These comments are in response to the Applicant's document REP4-018

## Thorpe on the Hill Parish Council - Interested Party Ref: [REDACTED]

### Fosse Green Energy (FGE) – Deadline 5

Proposed Permissive Paths Plan

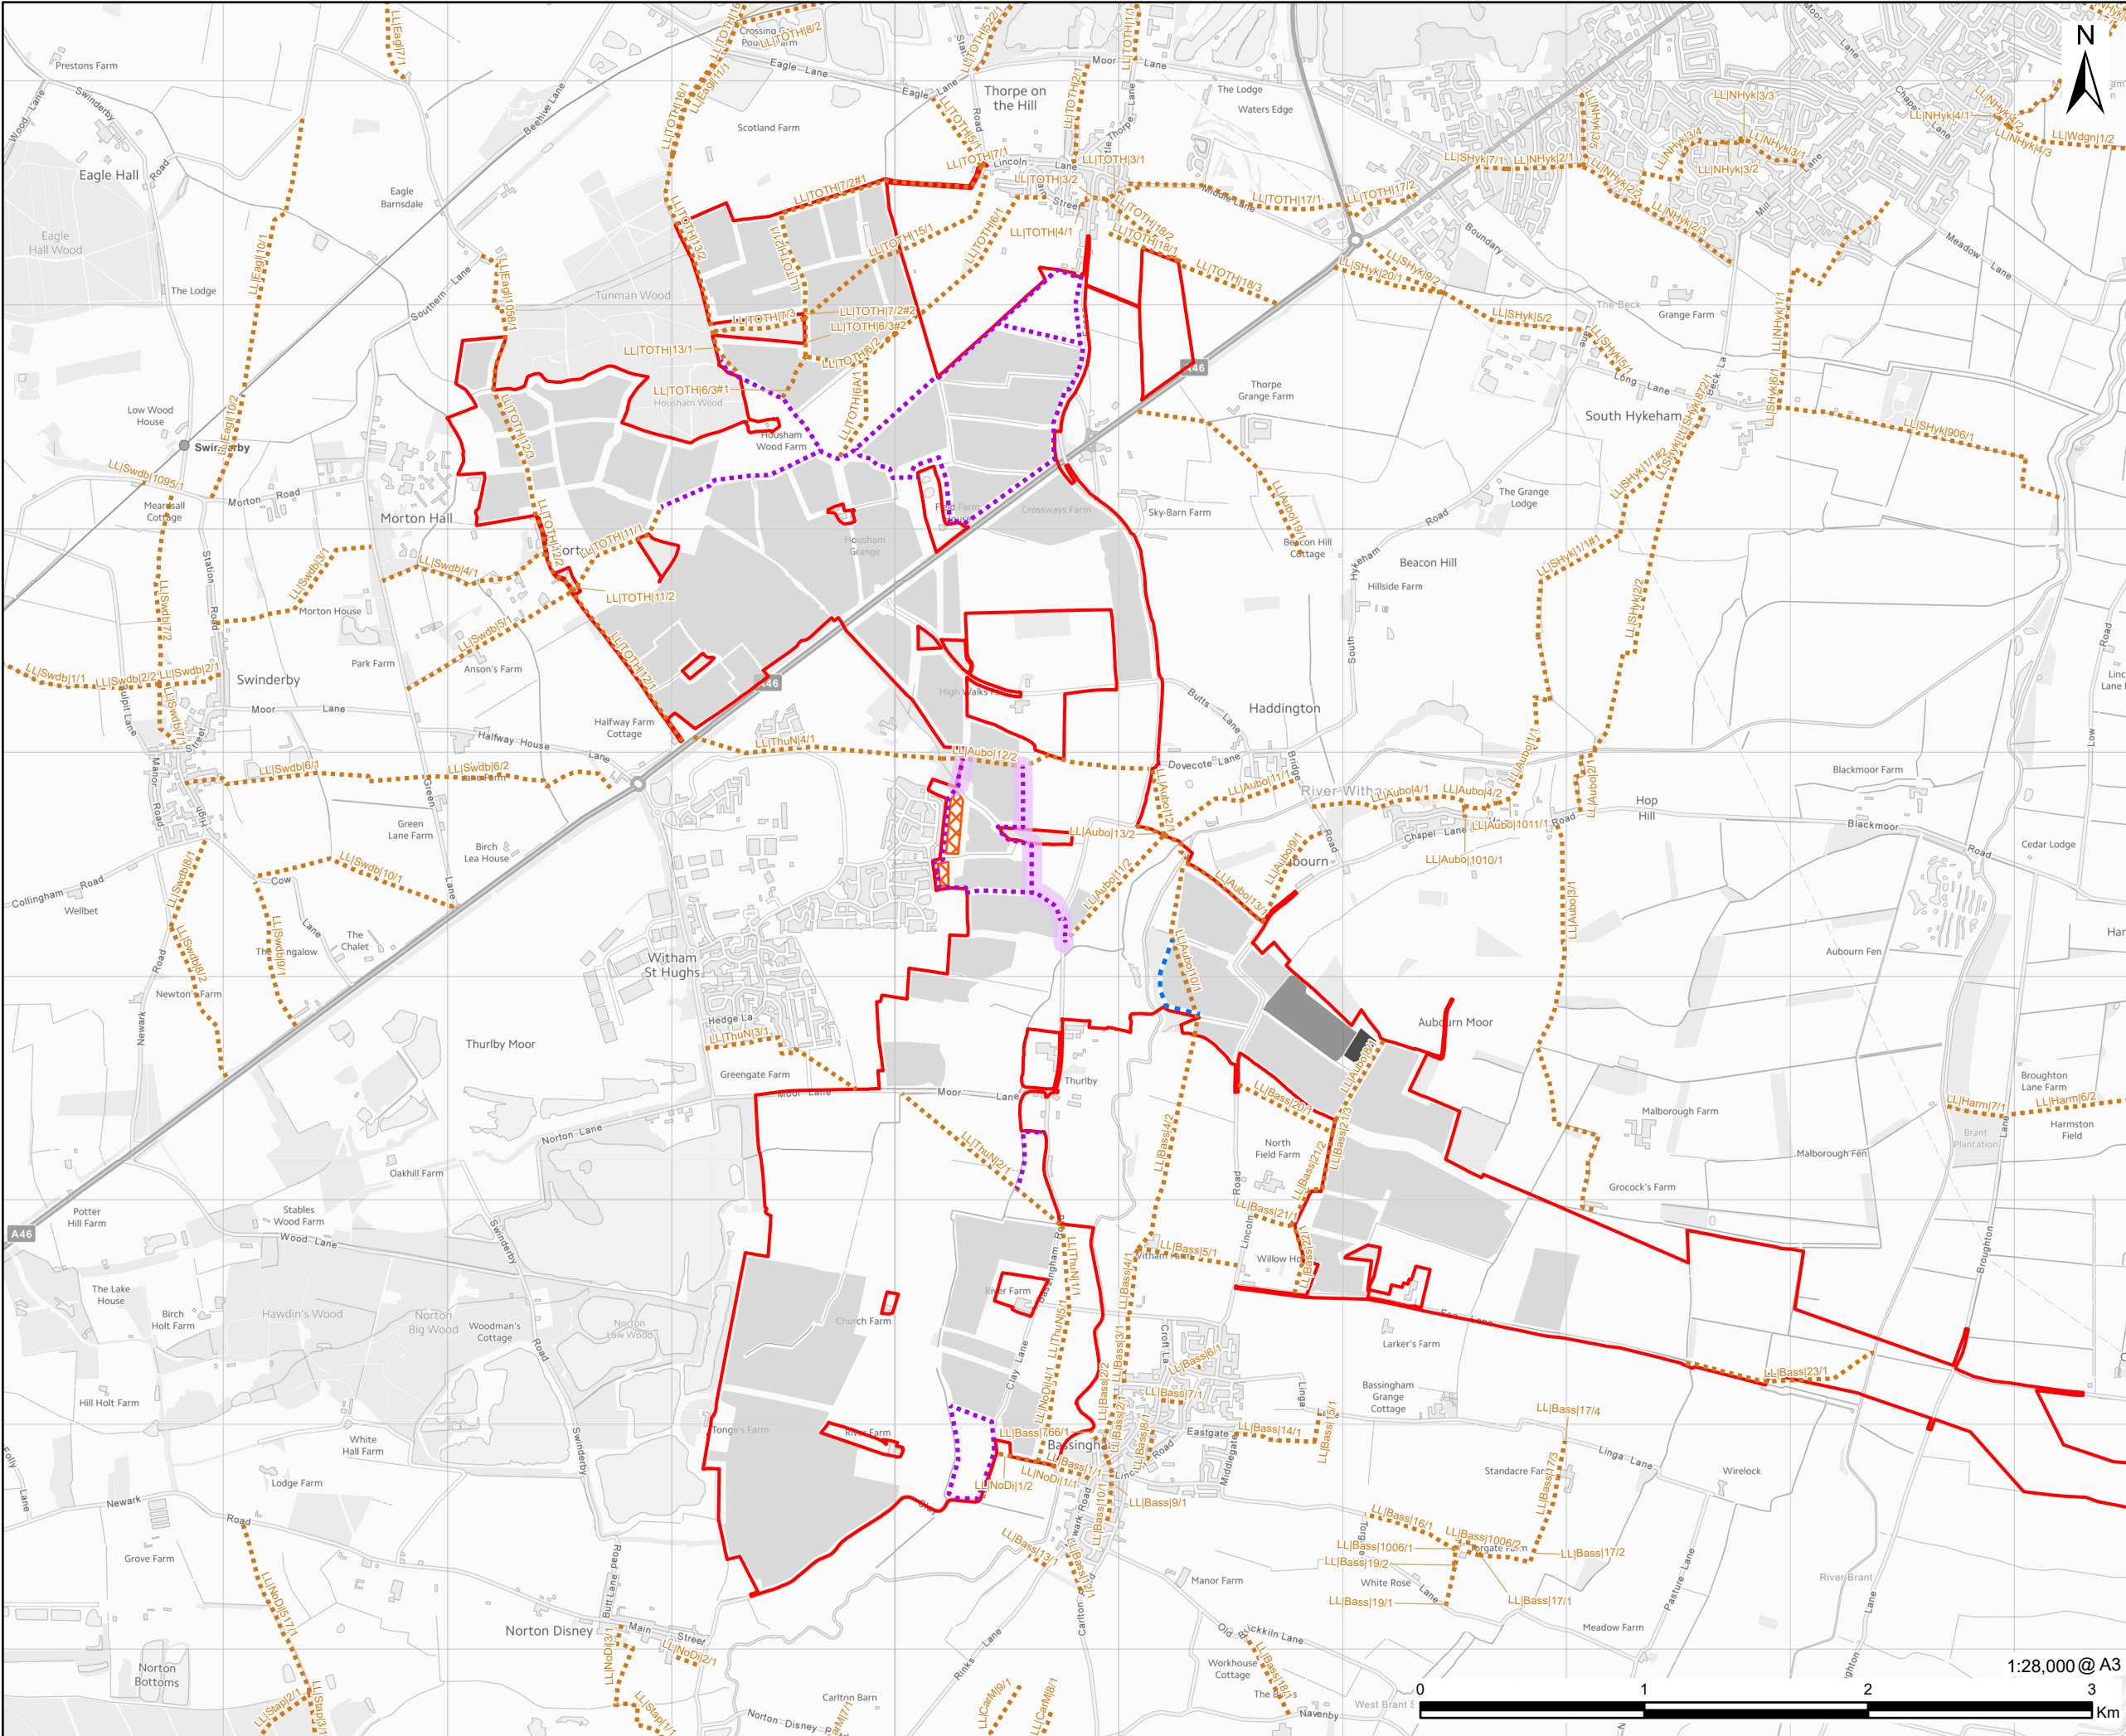
In their response to this proposal, which was offered in good faith to try and find a workable compromise, the applicant has rejected the scheme and has suggested that work-arounds in the form of new permissive paths provide an equally suitable, and perhaps enhanced alternative. These new permissive paths which the Applicant states will be defined in detail in a deadline 5 submission are clearly unavailable for scrutiny at this point, and therefore it is impossible to offer comments.

The PC broadly welcomes the creation of new permissive paths, but considers that those indicated to date are of primary benefit to the temporary residents of Cathedral View Holiday Park, rather than effective replacements for the loss of key parts of the Stepping Out routes.
